Jean Fraser - Re: 133 York comments needed urgently please

From: Jeff Tarling
To: Jean Fraser
Date: 9/6/2013 1:56 PM
Subject: Re: 133 York comments needed urgently please
CC: David Margolis-Pineo
Attachments: Portland Recm. Tree List.xls

I have reviewed the landscape plans for 133 York Street and offer the following review comments:

PLANT LIST

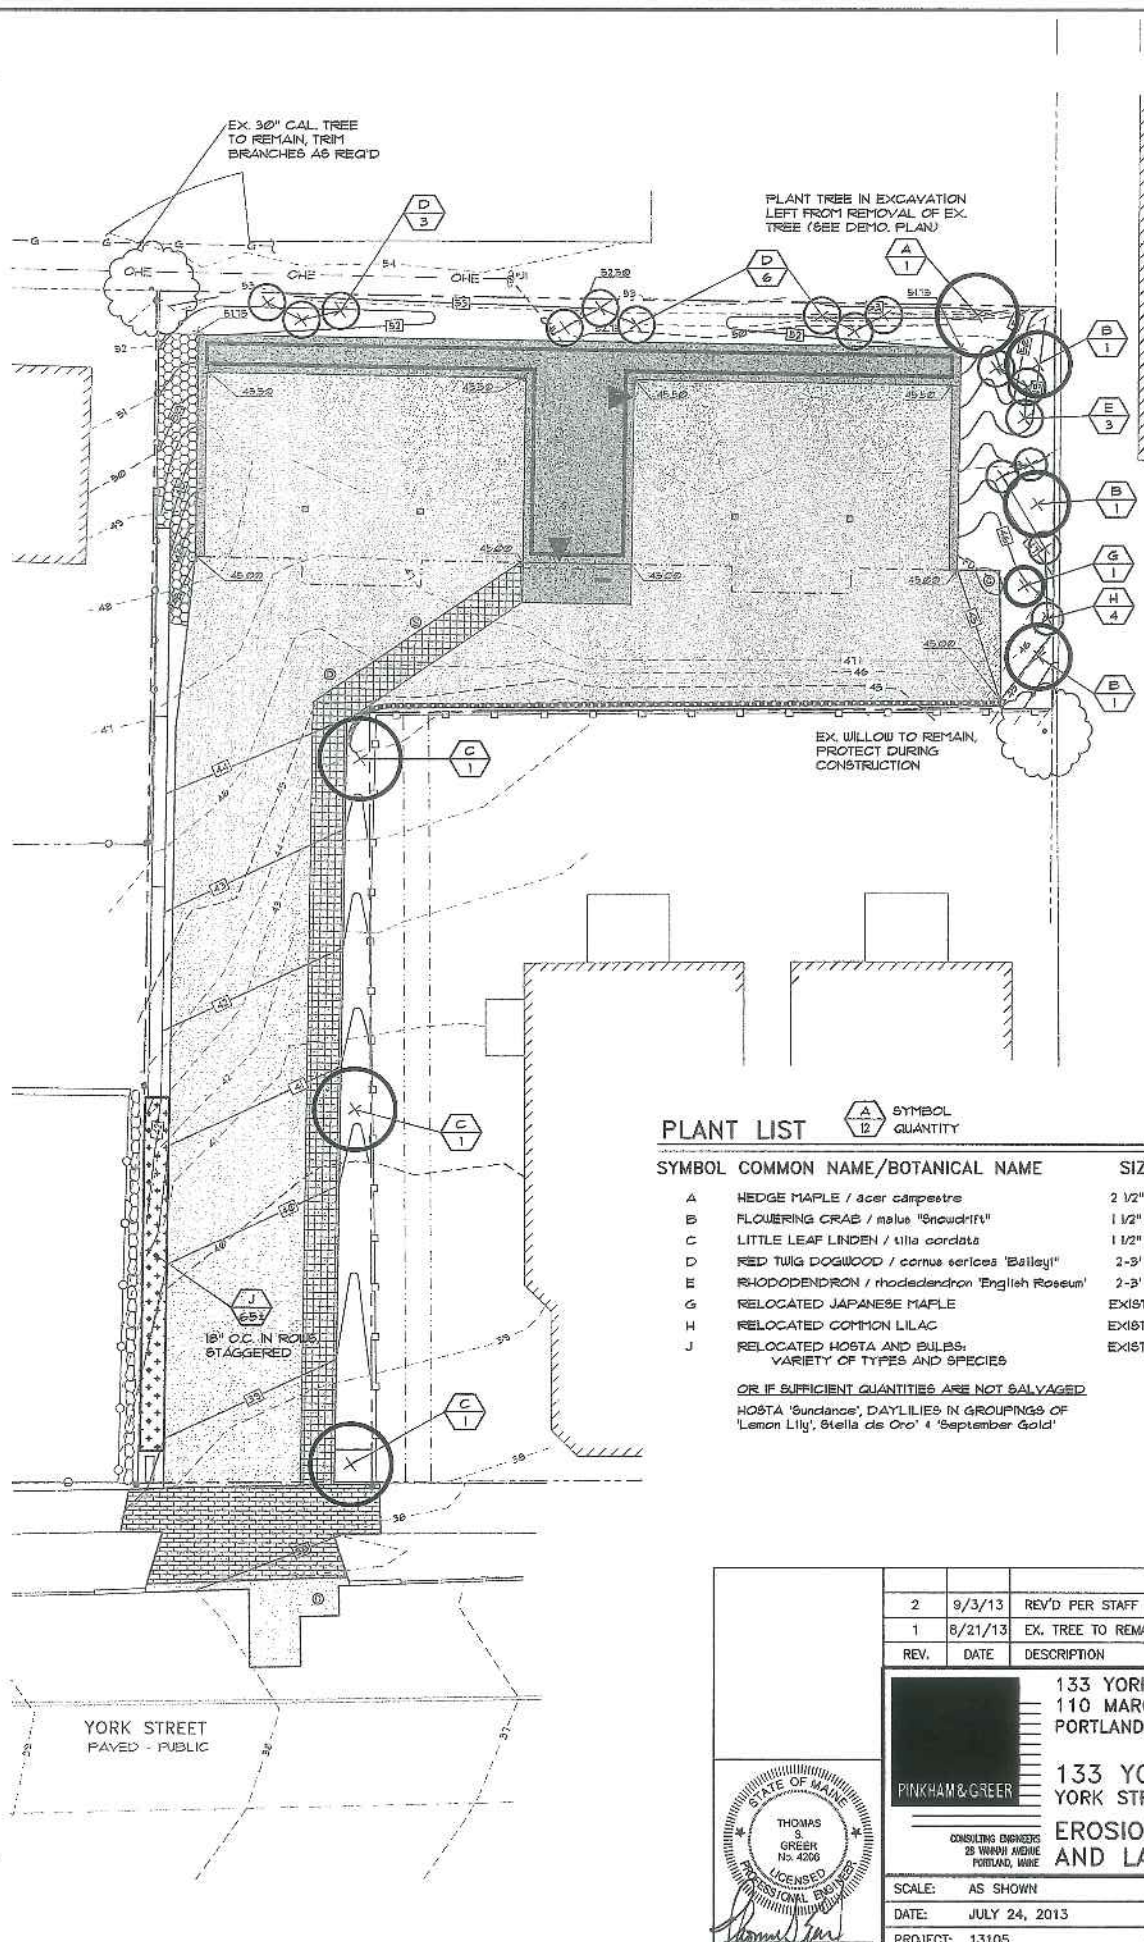
Recommendations: Additional buffering between the proposed project and brick residential property next door should be a requirement condition. The proposed projects driveway and parking is next to their backyard living space, patio & green space. Additional screening in the form of a 'green wall' and / or two to three columnar trees to be planted on the adjacent property would improve.

Additional buffering / landscape treatment condition #2 - the left side of the driveway at York Street for the first

40' (area of hash marks on plan) landscape planting or fencing to screen the side yard of the existing residential property next door. The landscape planting should provide screening or buffering as not to adversely affect the existing use next door. (I noted a small seating area on the lawn existing currently)

Tree Types - ALL trees should be from the City of Portland recommended list, (Little-leaf Linden is no longer on our recommended list). Suggestions might include: 'Karpick' or 'Red Point' Red Maple, 'Armstrong' Red Maple, the first two are a little less columnar the Armstrong, European

Hornbeam, upright Pin Oak also would work, this is the same for the lawn area trees above if needed.

Tree Saves - Tree protection measures should be included in the final plan and in the field as part of the preconstruction meeting. 'Tree Save' / protection for the root zone of the large Willow tree off site might include fencing if needed, see: http://www.treesaregood.com/treecare/avoiding_construction.aspx

The existing American Elm near the SW corner is next to a large Norway Maple - unknown if this can be saved.

It appears to be near the property line and would need to be limbed up for construction. Elm trees should only be pruned during the dormant season to reduce Dutch Elm Disease as fresh cuts attract Elm Bark Beetles.

Relocated Plants - While it is great to try to save existing plants 99% of the time it is unsuccessful due to timing, transplant shock, storage etc during project time line. Thus, all plants shown as to be relocated must be included as new plants and included into the performance guarantees in case the transplants are not successful.

Cobblestone or granite paver driveway & sidewalk - These existing features could add some historic interest to the site and should be considered for saving & reuse. Our HP office & Public Services can offer suggestions.
